**Consultation Response from KC Children - Commissioning****2025/92872 24, Thornleigh Road, Crosland Moor, Huddersfield, HD4 5PY****Change of use from residential dwelling (Class C3) to children's care home (Class C2) with hip to gable alteration and erection of rear dormer****Date Responded: 11<sup>th</sup> November 2025****Responding Officer: Gary Wainwright, Children's Commissioning Manager****Responding Ref:****Re: Change of use from residential dwelling (Class C3) to children's care home (Class C2) with hip to gable alteration and erection of rear dormer**

SCALE: 1:100(A3) | DATE: SEP 2025 | DRAWN BY: ZESHAN KHAWAJA
PLANNING/BUILD REGS | DRAWING NUMBER: 25/4089/SS2

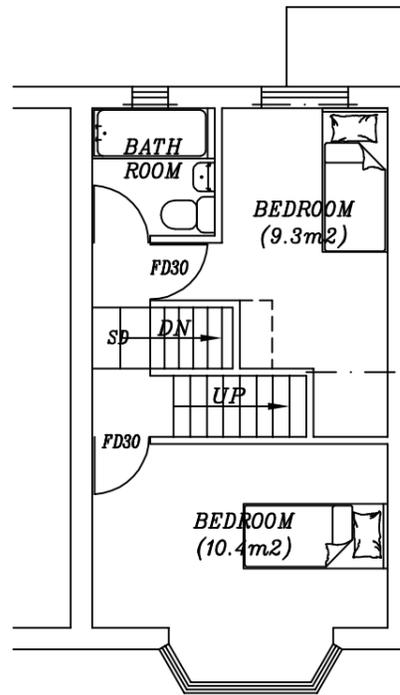
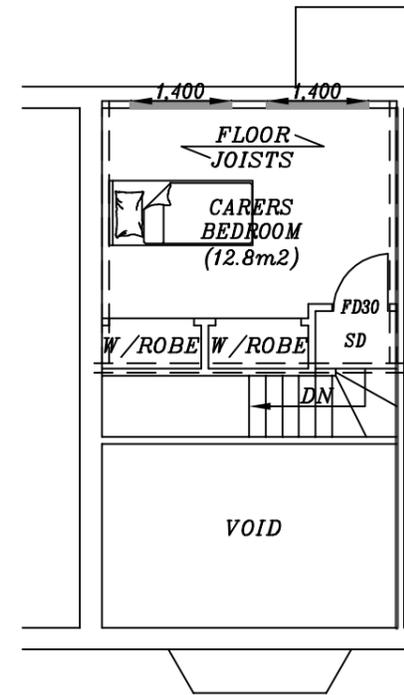
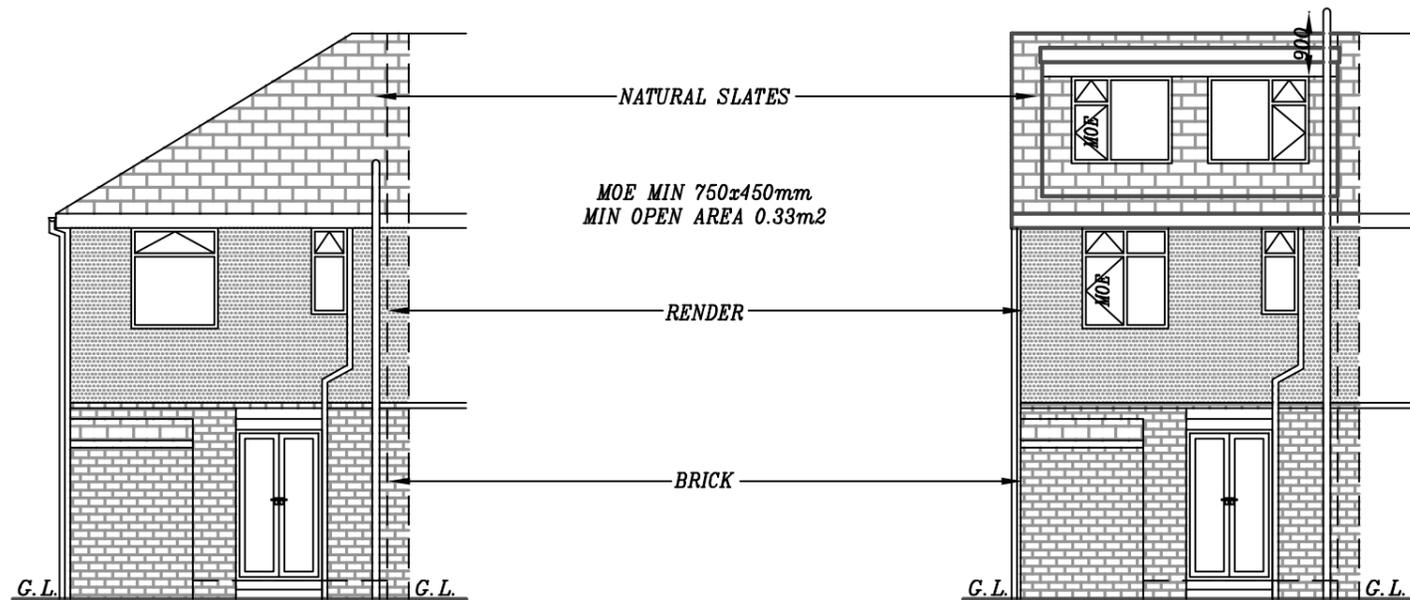
The proposed plans show only one staff bedroom, that is not sufficient for the proposed minimum of 2 staff sleeping staff. There is only one bathroom in the proposed plans for both children and staff.
